Morgan and Morecambe Offshore Wind Farm: Transmission Assets

Appendix G3 to Natural England's Deadline 3 Submission
Natural England's further advice on Onshore Ecology and Nature Conservation

Planning Inspectorate Reference EN020028

07 July 2025

**Figure 1.5: St Annes Old Links Golf Course BHS and Blackpool South Railway BHS close view**

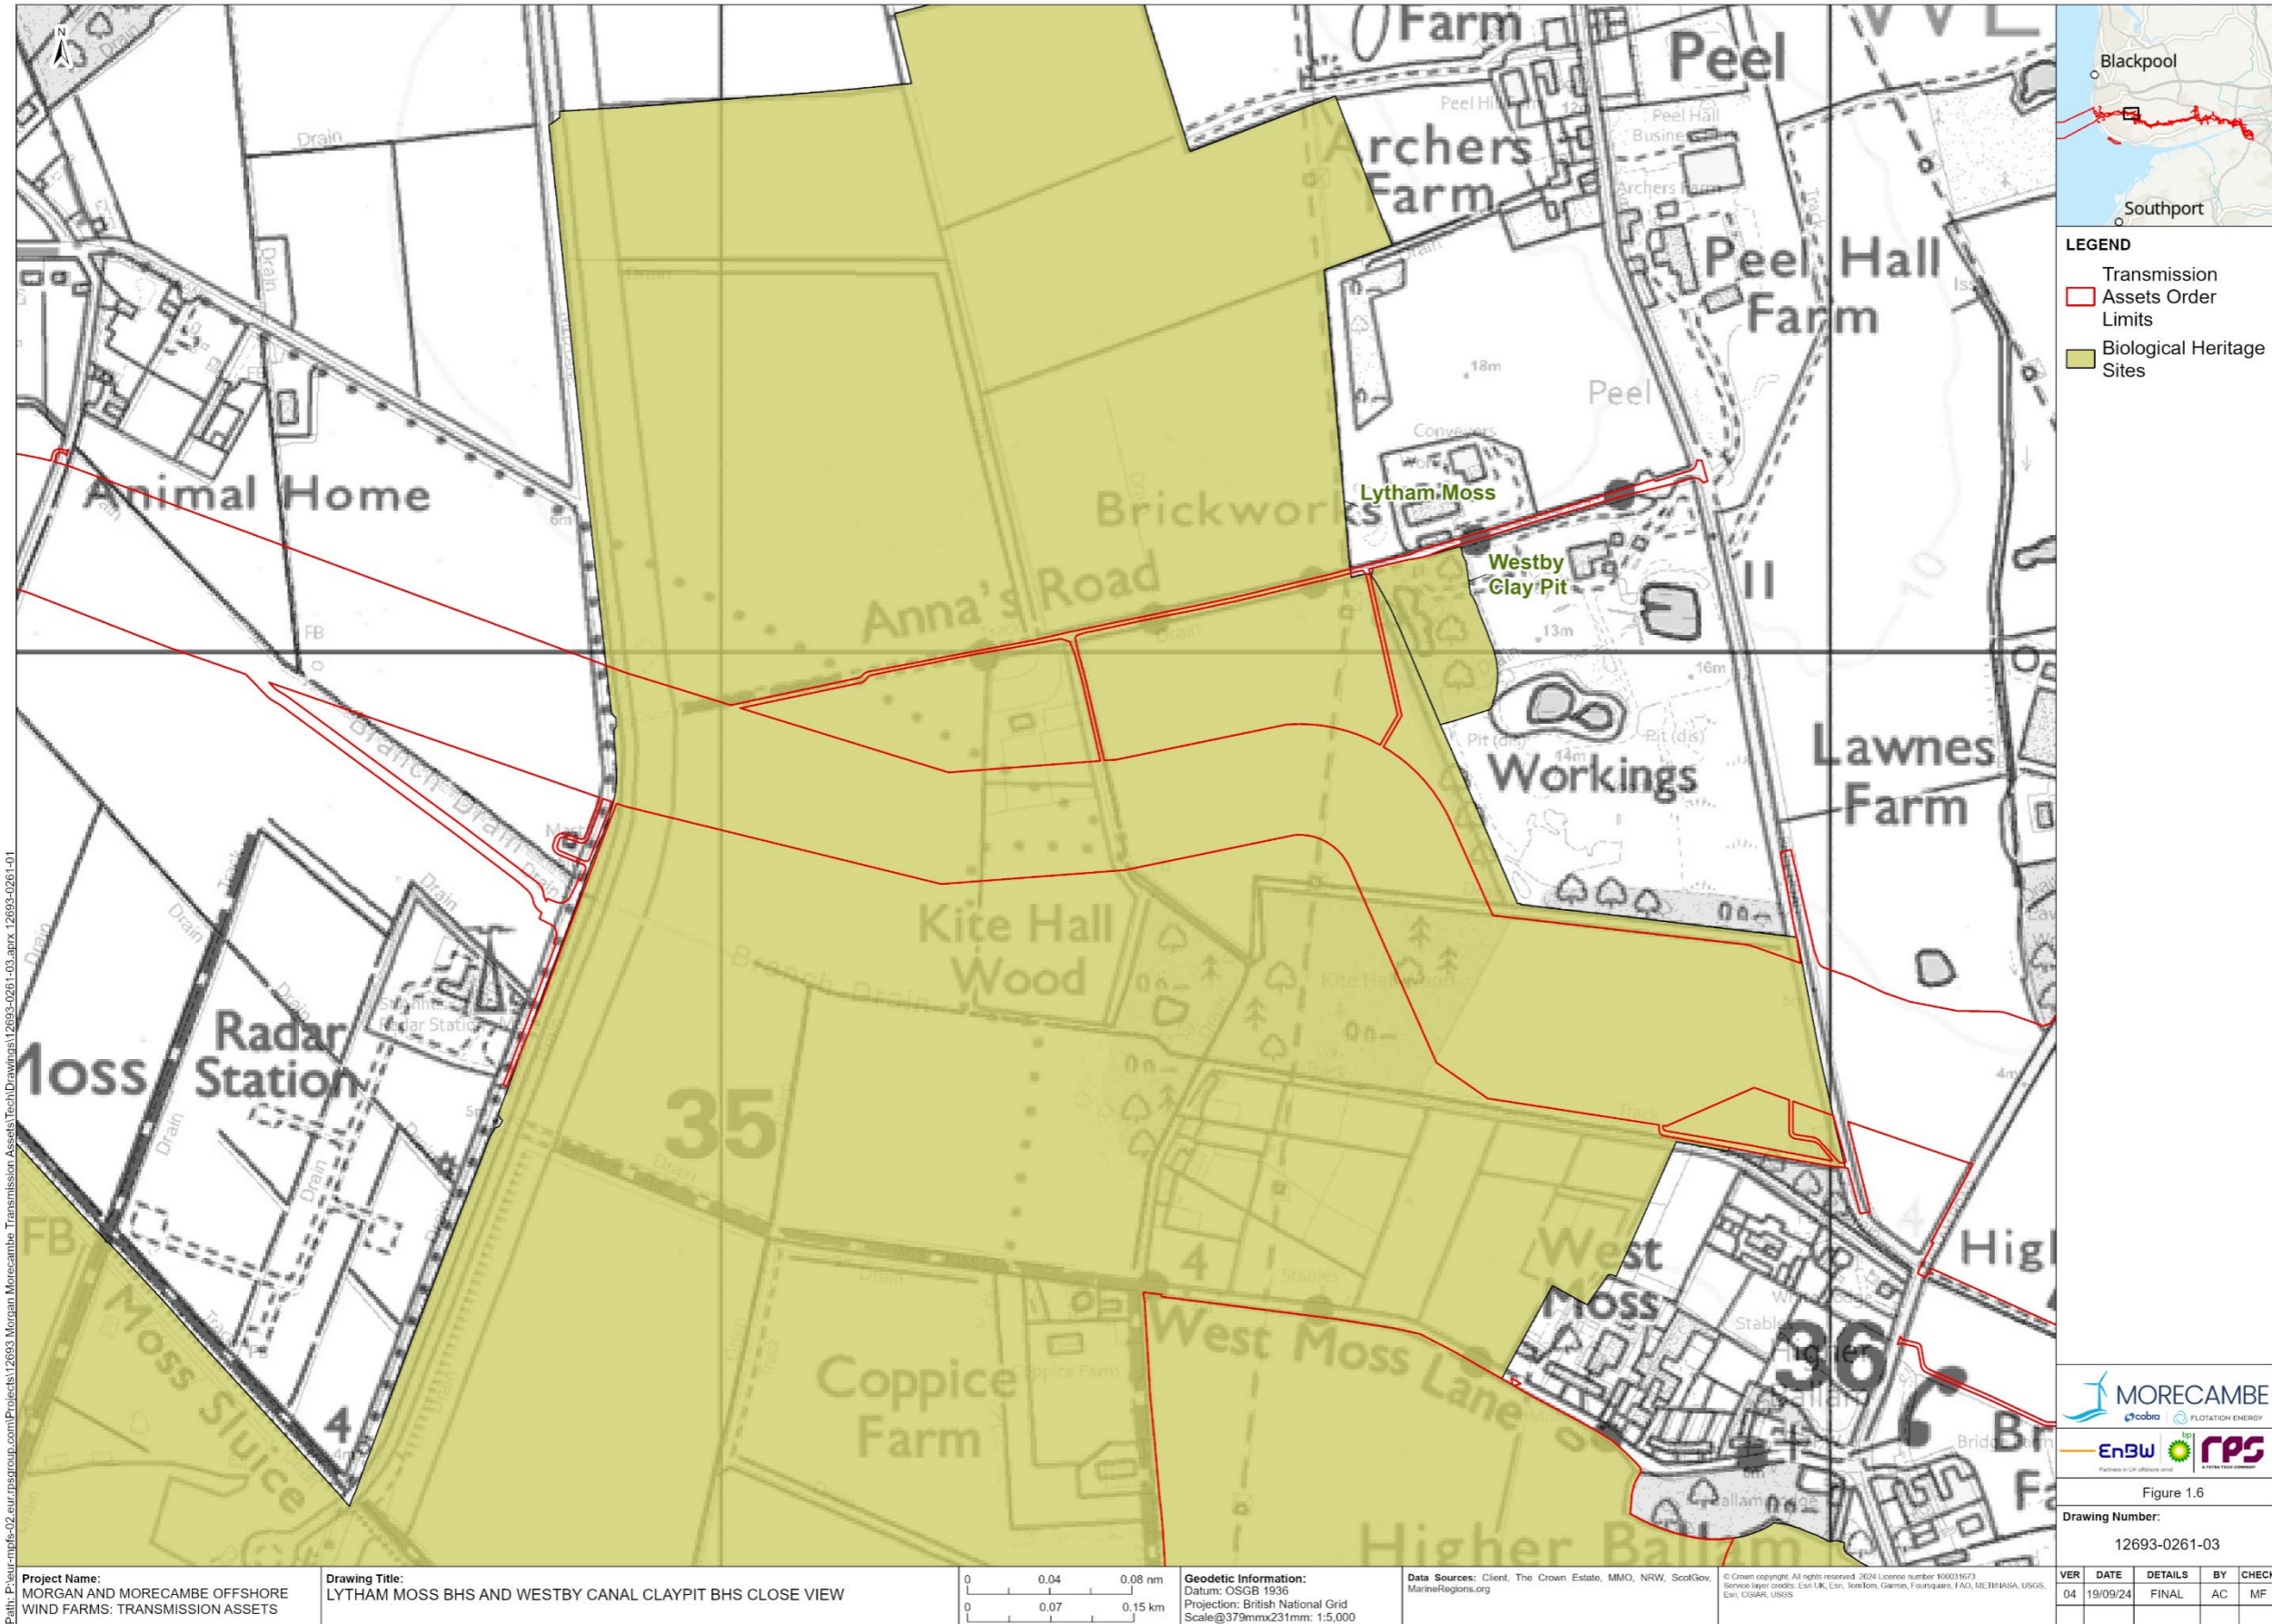
However, we reiterated the need for further survey effort in order to help our understanding of likely impacts to the SSSI sand dune features, in particular the dune slacks and adjacent BHS supporting S41 Priority Sand Dune habitat. Dune slacks are ground water and rainwater dependant features. Therefore, we advise that the further data includes NVC surveys of the sand dunes, and installation of dipwells and dataloggers to monitor the position of the water table and to record potential fluctuations that may arise as part of the proposals over the lifetime of the project. We understand data from the abstraction borehole ref: GWA_01 may also be available and that the borehole itself may be able to help understand the position of the sites water table.

To date, the Applicant has presented a historical NVC survey of the SSSI (undertaken in 2016 by Skelcher for the Fylde Sand Dune Project Steering Group). However, this survey data is 9 years old and the survey does not cover the adjacent St Annes Old Links Golf Club which is the BHS.
